**RE: Iron Duplex  
1203 Iron SW  
Grading and Drainage Plan  
Engineers Stamp Date 11/22/16 (K13D074)**

**From:** Carrillo, Abiel X.  
**Sent:** Monday, November 21, 2016 11:53 AM  
**To:** David Soule  
**Subject:** Iron Duplex - K13D074 - Stamp Date 11-2-2016

GRADING AND DRAINAGE PLAN

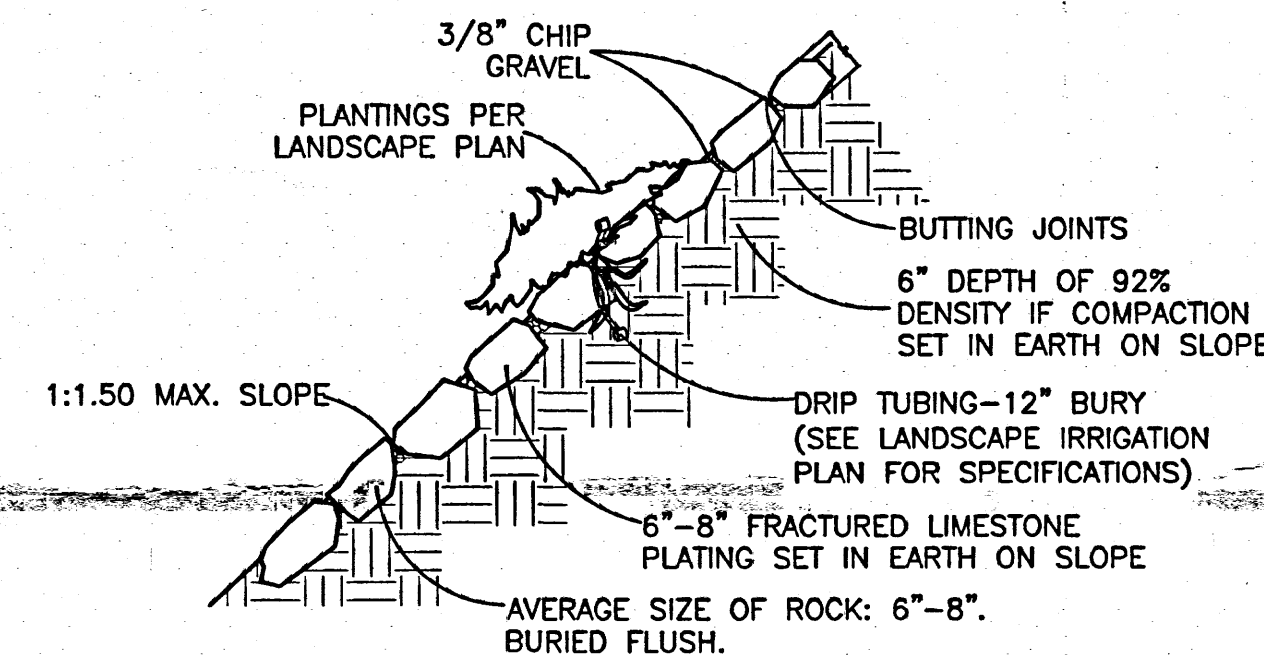
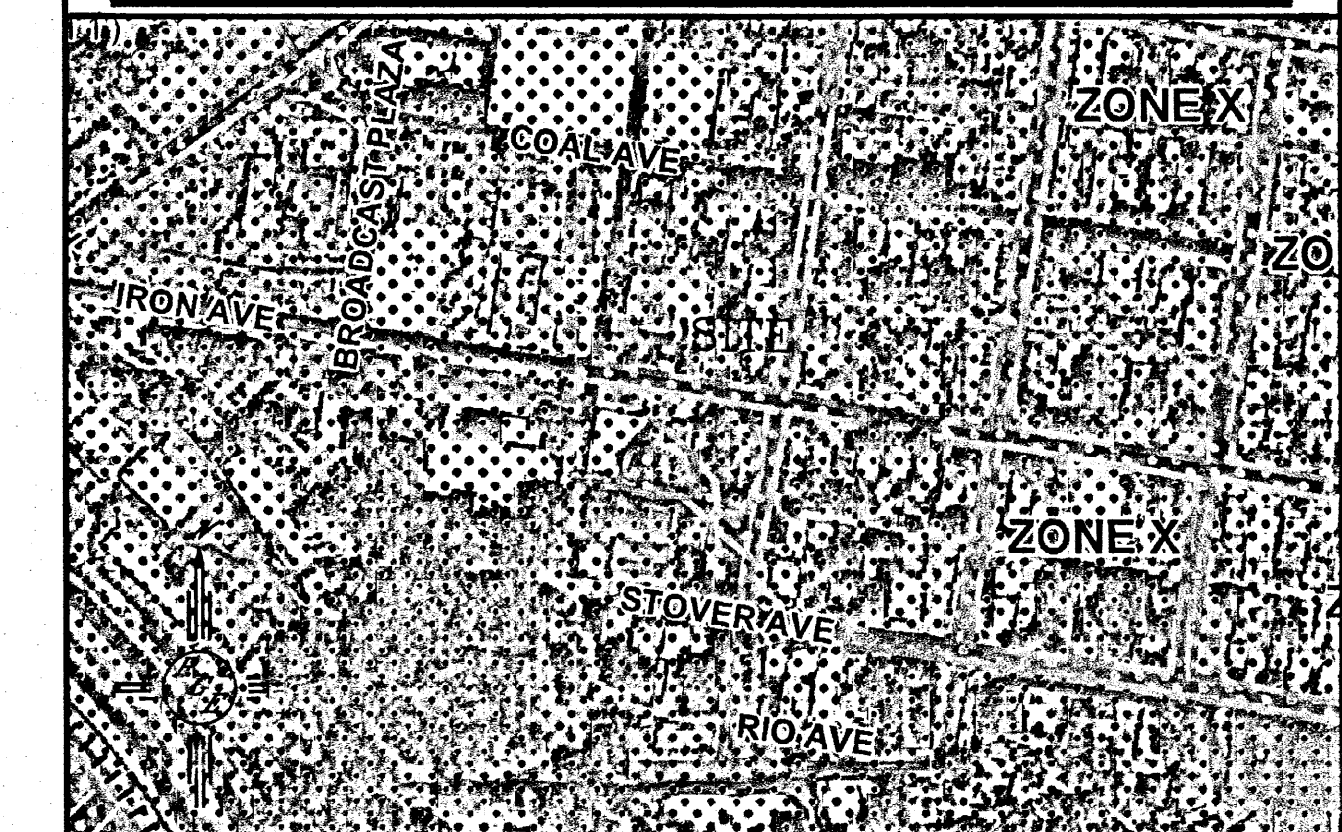
1. Clarify the contour and surface work to be completed adjacent to the alley.
  - a. The linework suggests that parking spots are to be developed, are they paved? ✓
  - b. The contours of the pond seem to grade the pond off center, steepening the side slopes adjacent to the parking lot. ✓
2. The concrete alley appears to be cracked throughout its length. The contractor will be required to sawcut and repair those portions of the concrete alley that are degraded by the construction of the improvements. ✓
3. The site is zoned SU-2, does the project need Site Plan approval?
4. How does the roof drain? It should not discharge directly onto the sidewalk.
